Vacate unused utility easement in backyard of property.

Re: Vacation of Utility Easement at 8035 Kibo Dr. NW

**PS-2023-00087 – SKETCH PLAT**

**Project Name:** Vacation of Utility Easement at 8035 Kibo Dr. NW

Proposed Utility Easement Vacation

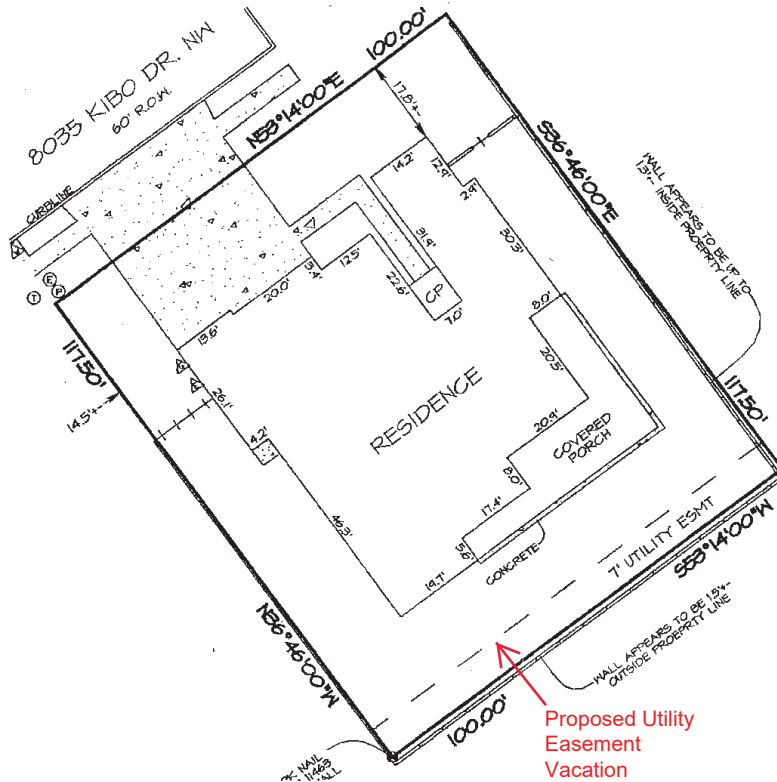
- 5-1(G) Exceptions and Encroachments **may encroach into a required setback, but in-ground swimming pools shall not be closer than 5 ft. from any lot line or building.** Measurements taken from site plan indicate ~15' rear setback if vacation of utility easement is granted. This would allow 5' width pool.

- Retention pond shown on Grading & Drainage plan approved by Hydrology on 12/11/2020 was required for approval of Grading & Drainage plan. Where will retention pond be relocated to? **Manage stormwater per Subsection 14-16-5-4(H).**
